**RE: 1-11 Australia Avenue, Sydney Olympic Park, Ref: MP10_0027 MOD 1
Response to SOPA letter of 12. June 2012**

We write on behalf of the Proponent, Site 3 Development Company Pty Ltd in response to your request for a written response to the letter of Sydney Olympic Park Authority dated 12 June 2012. We note that SOPA do not raise objection to the proposal provided the matters raised in the letter are satisfactorily addressed. The following table provides SOPA's comments and the Proponent response:

Site 3
Sydney Olympic Park
Plan
Level 23

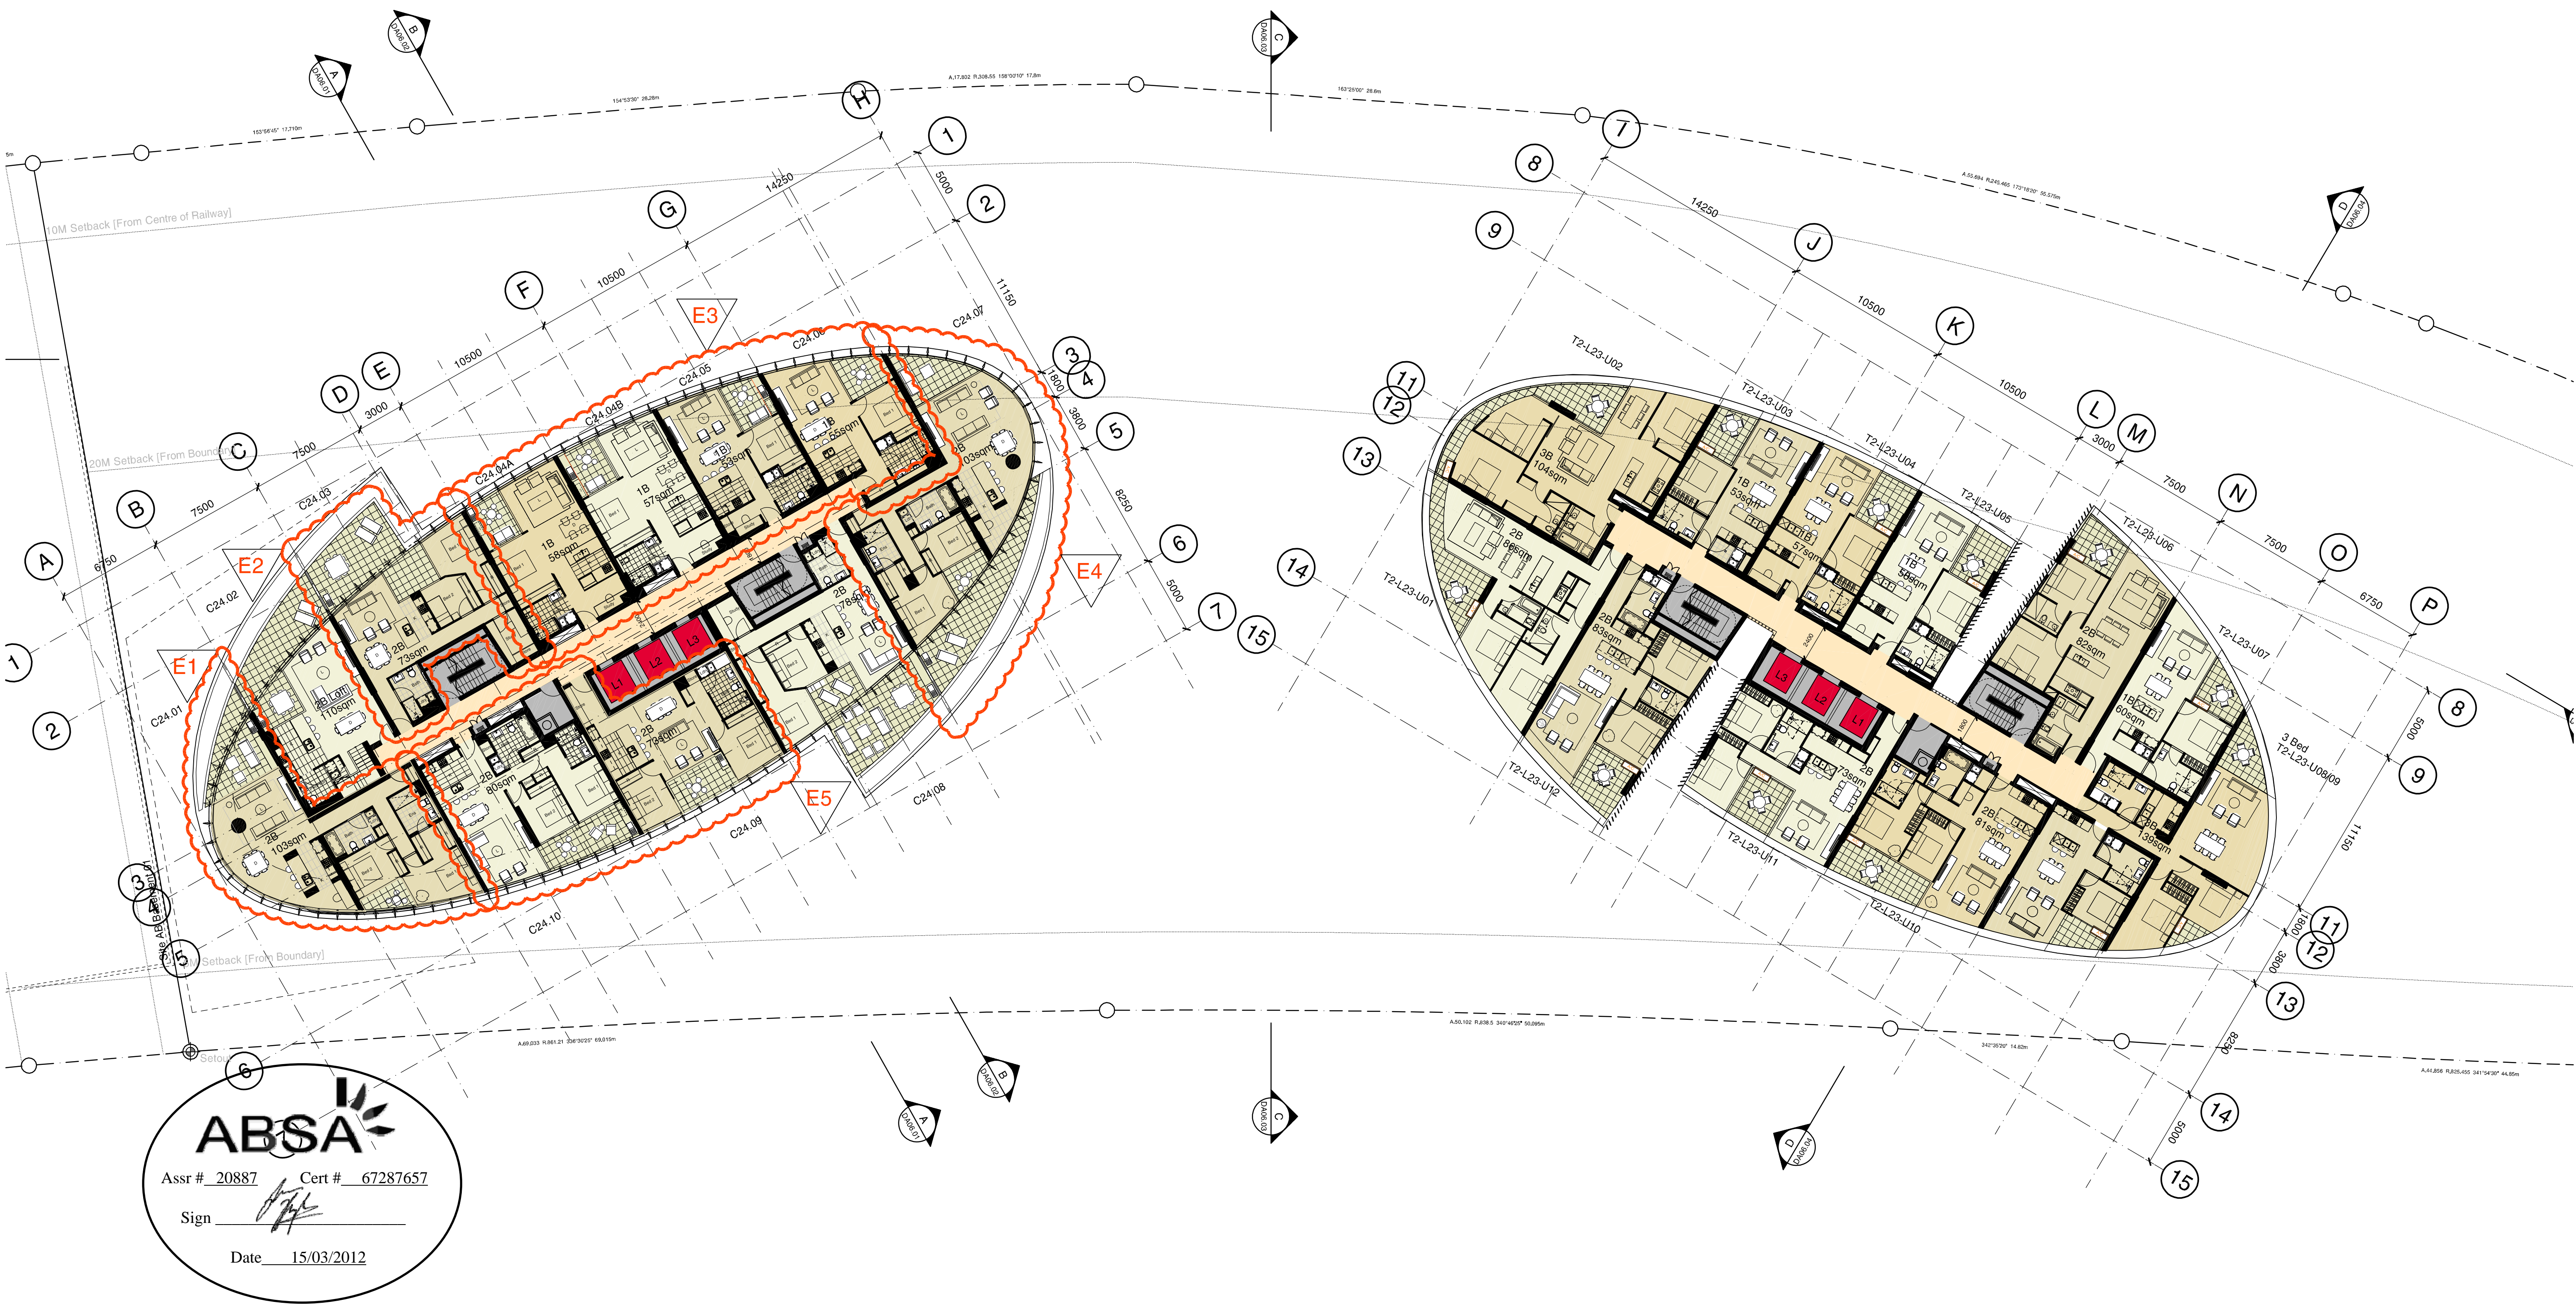
<p>3. Balconies</p> <p><i>The change in unit mix has resulted in new triangular balconies that are less than 2m² in area and almost unusable. It is recommended that the additional FSR achieved through internal efficiencies (52m² in total according to the proponent) be invested back into providing balconies of greater than 2m².</i></p>	<p>The balconies referred to by SOPA appear to be those at Levels 12, 19-21, 22 and 23 which are secondary balconies located off a bedroom. Useable balconies are provided to units off- a living room in accordance with SEPP 65 and the NSW Residential Flat Design Code 2030 and the Sydney Olympic Park Master Plan 2030.</p> <p>Clause 4.6.17 (11) of the SOP Master Plan 2030 states that the:</p>

SOPA comment	Proponent response
	<p><i>"11. Secondary balconies are encouraged as service areas, to alleviate uses dependent on the primary balcony and to increase connection between inside and outside".</i></p> <p>The NSW RFDC 2002 states in relation to secondary balconies that:</p> <p><i>"Consider secondary balconies, including Juliet balconies or operable walls with balustrades, for additional amenity and choice:</i></p> <ul style="list-style-type: none"> ▪ <i>In larger apartments;</i> ▪ <i>Adjacent to bedrooms;</i> ▪ <i>For clothes drying, site balconies off laundries or bathrooms; they should be creased from the public domain".</i> <p>It is appropriate to provide smaller secondary balconies off bedrooms in the proposed development to free up space on the larger primary balconies for a table and chairs and general use. Secondary balconies are often useful as a place to put running runs to air or a clothes rack.</p>

Site 3
Sydney Olympic Park
Plan
Level 24

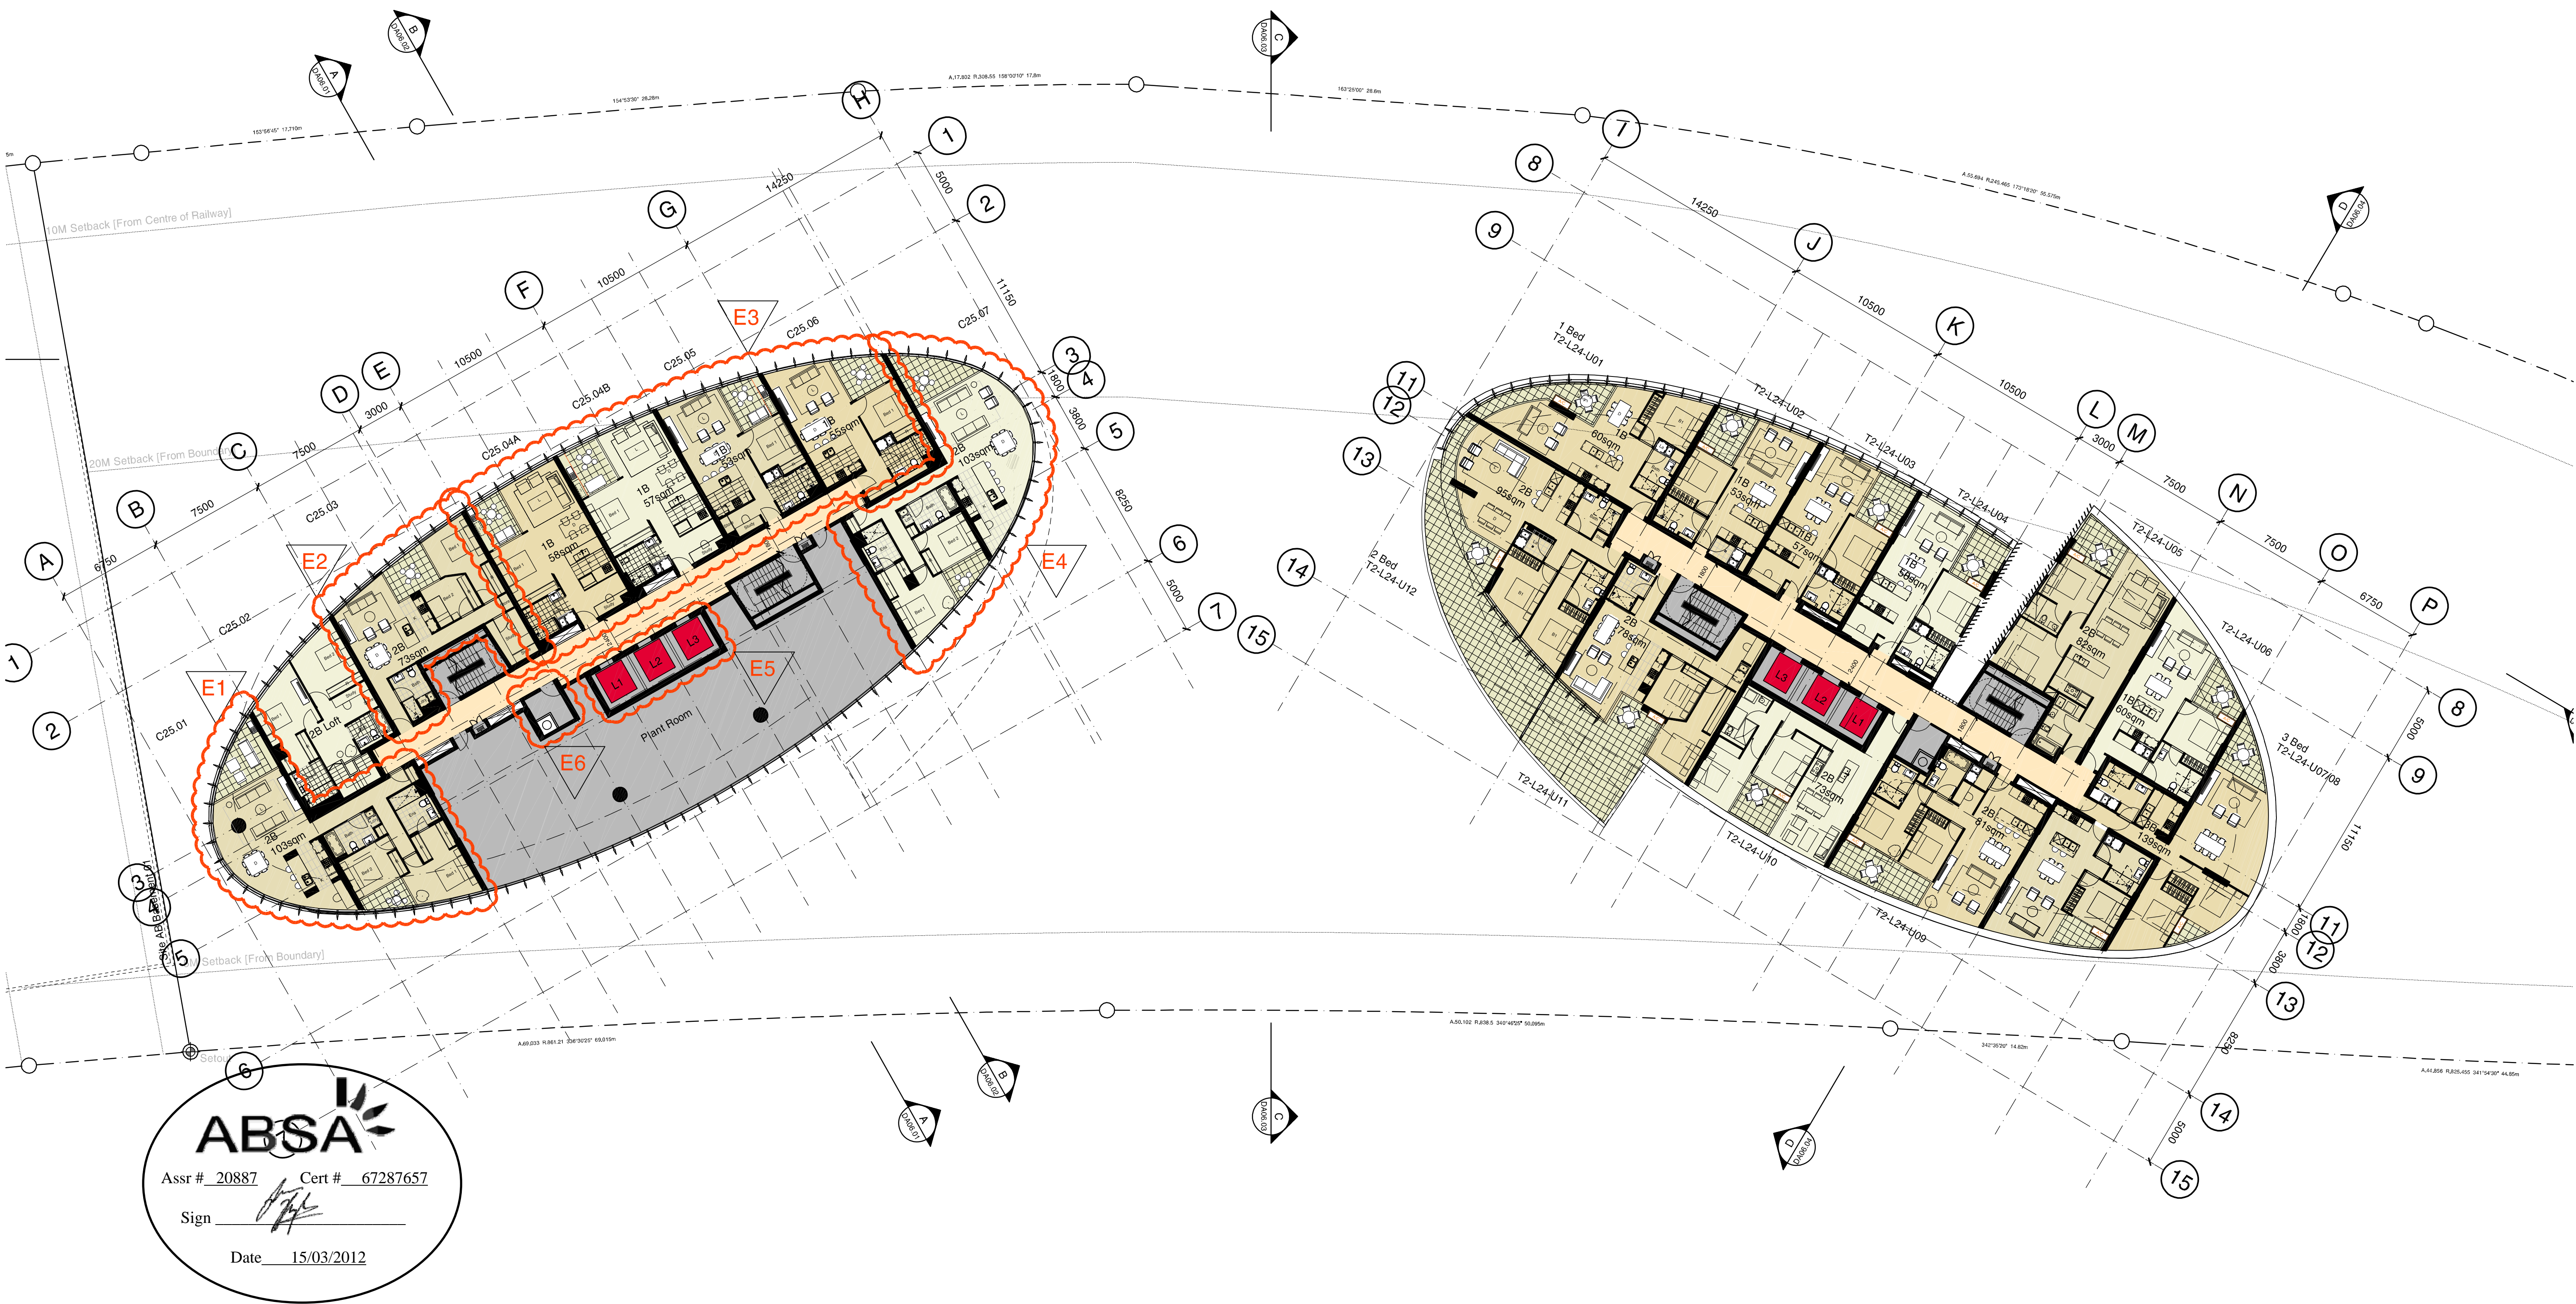
SOPA comment	Proponent response
<p><i>solid, in particular:</i></p> <ul style="list-style-type: none"> ▪ <i>Smaller, shallower balconies and fewer external wall surfaces set back from the building edge are less effective in counteracting the mass of these large elevations.</i> ▪ <i>Removal of 2-storey loft units reduces the variety and changes the proportion of the upper levels. The removal of the loft units also means that there is less light penetrating through the 2-storey voids into the Level 23 living area.</i> ▪ <i>Infilling the void areas at each of Level 24 reduces the variety, transparency, and solar access to the upper levels.</i> 	<p>The removal of loft units will not have a significant effect on the building's external articulation and fenestration, given these the facades surrounding these units have a glazed 'skin' with external sun shading that is not proposed to change.</p> <p>Balconies introduced at Level 24 in place of voids will provide depth to the facade articulation as well as transparency in a similar way to the voids.</p> <p>In terms of light penetration into the Level 23 apartments, this is true that the replacement of the voids with balconies means less light to Level 23. The proposed development overall compiles with the requirements for direct solar access to living rooms and private open space in accordance with the rules of thumb under SEPP 65 and the RDFC.</p> <p>The solar access report prepared by Windtech and submitted with the Section 75W modification application at Appendix D of the Environmental Assessment shows that a great majority of units on both Level 23 and 24 will have excellent solar amenity (regardless of voids).</p>
